The Planning Act 2008
Sizewell C (SZC)

Planning Inspectorate Reference: *EN010012*

Deadline 10 – *12 October 2021*

East Suffolk Council comments on Deadline 9 submissions from the Applicant

Figure 2.3: Landscape and seascape designations

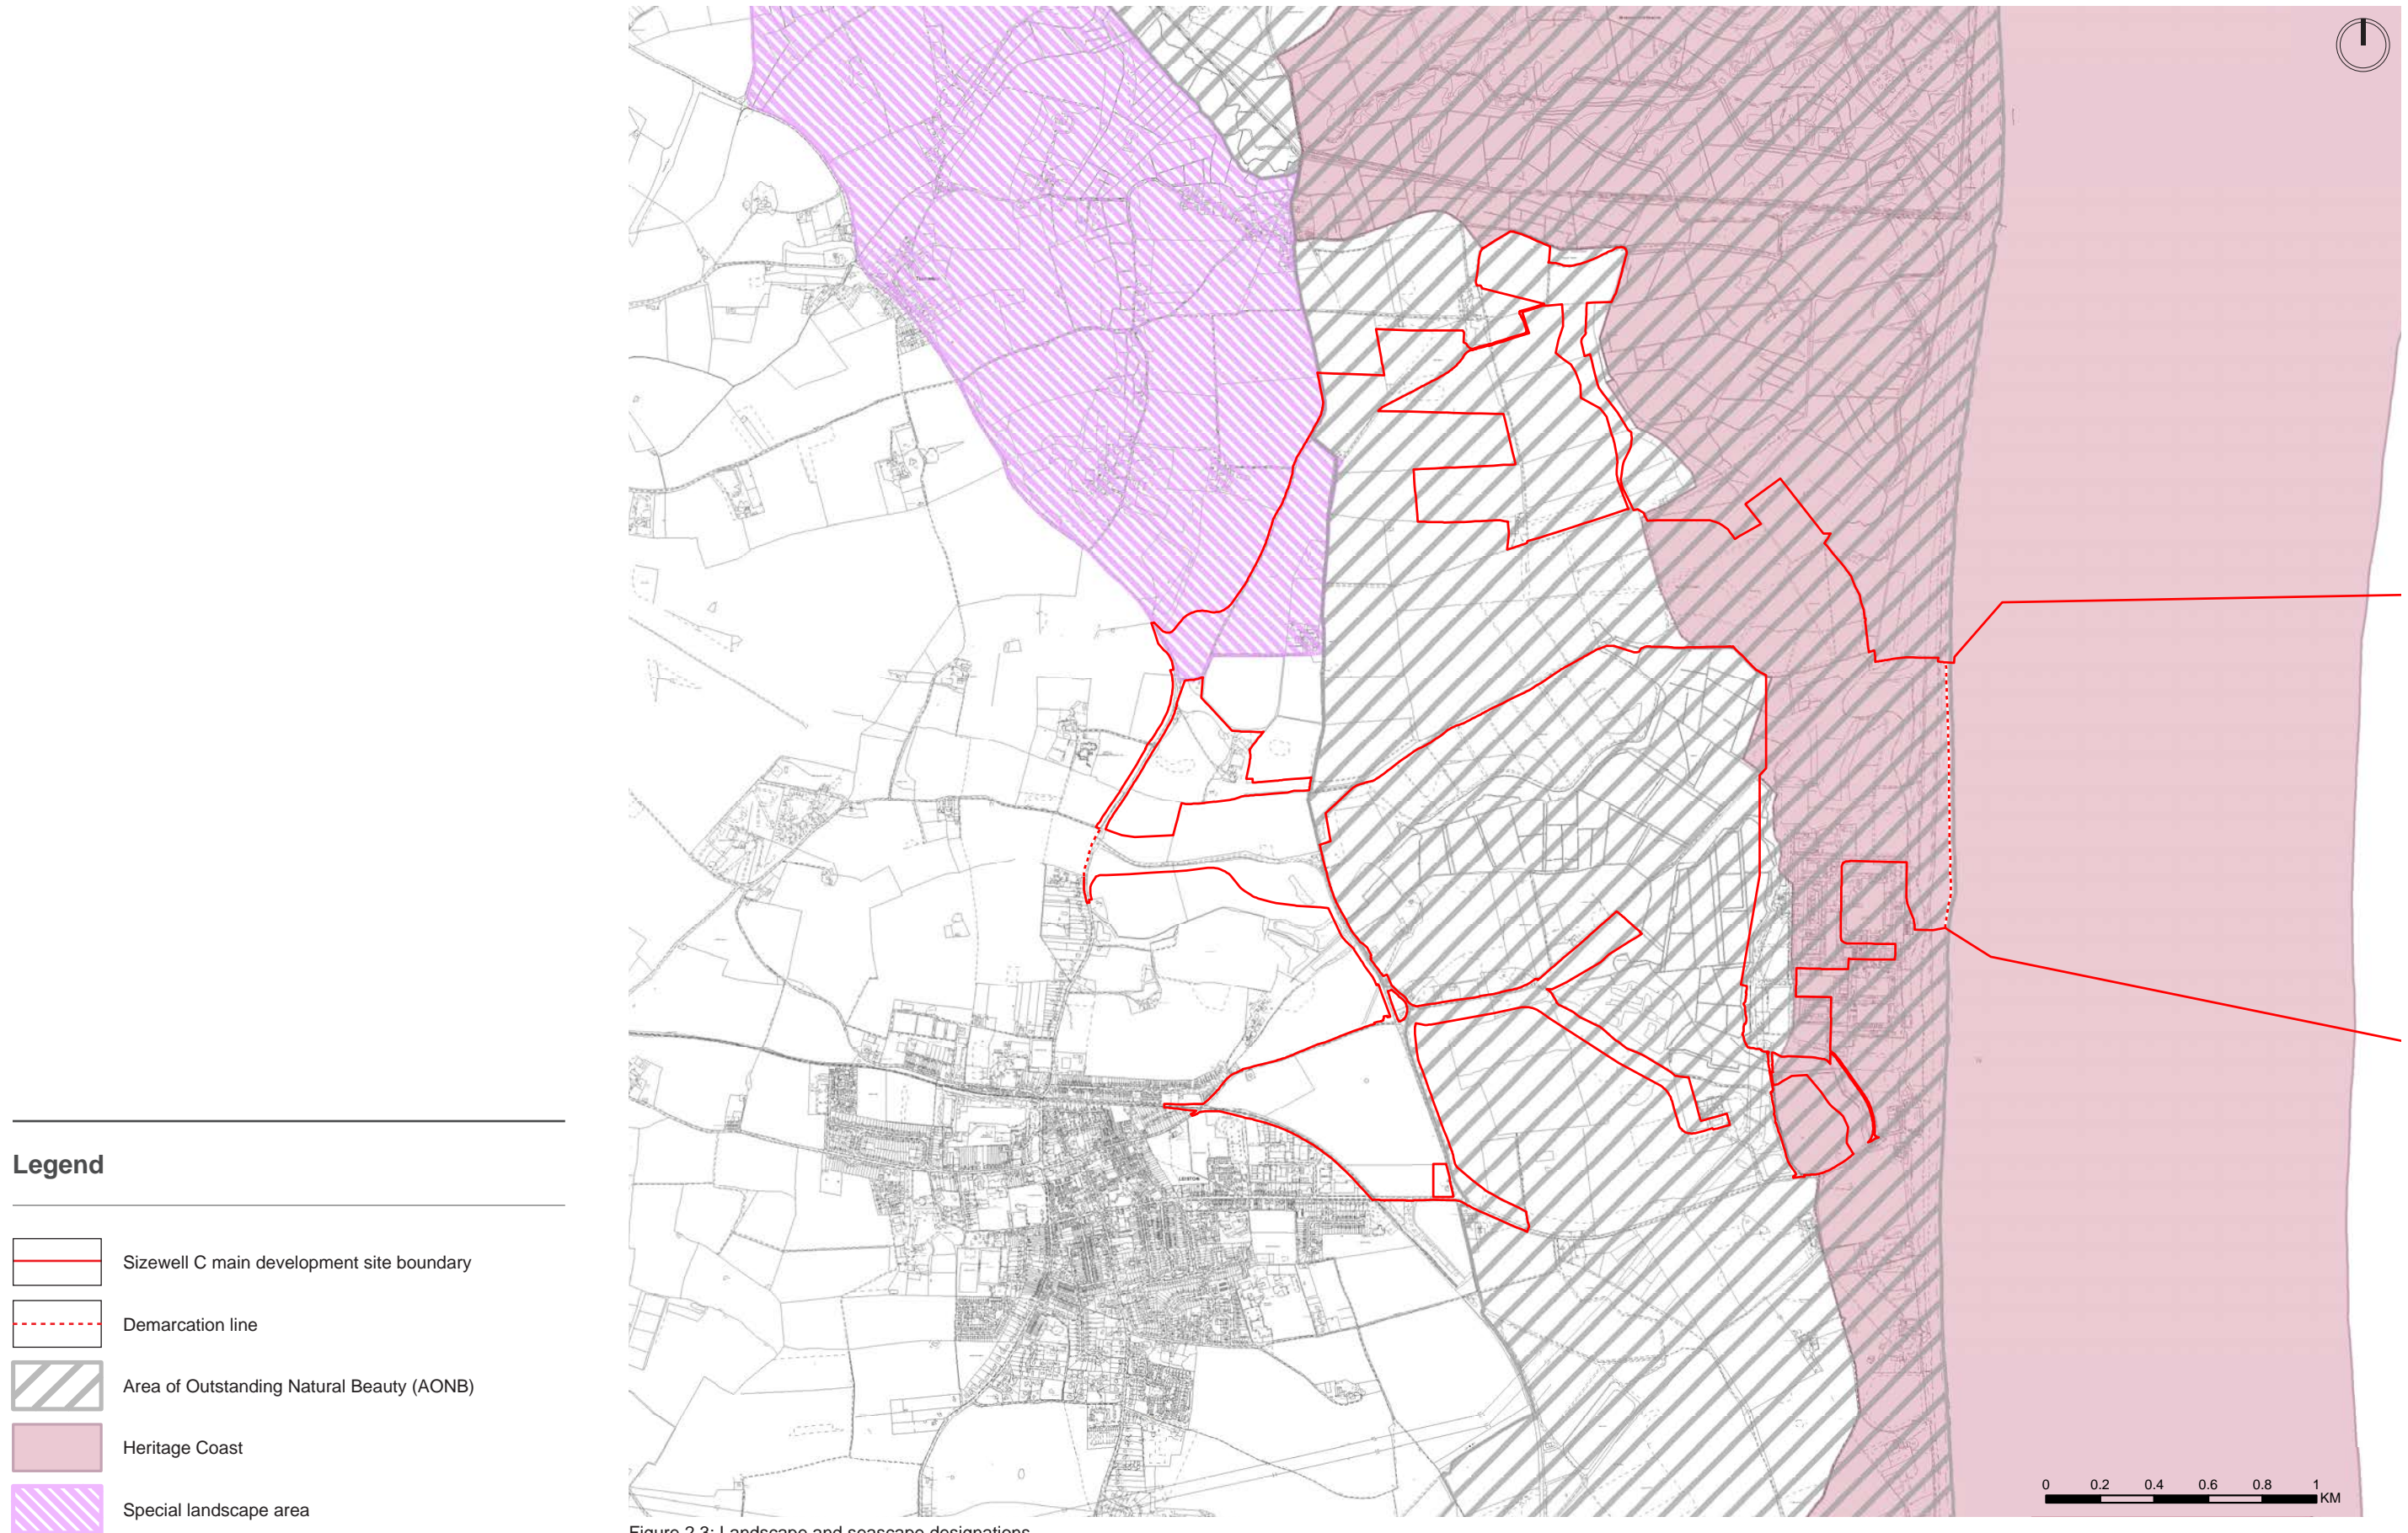
Page 24, paragraph, 2.5.1, paragraph 2.4.13 and page 25, Figure 2.3 Landscape and Seascape designations – these paragraphs, the associated figure, and its key, still include reference to, and show Special Landscape Areas and describe their local designation – this needs to be removed.
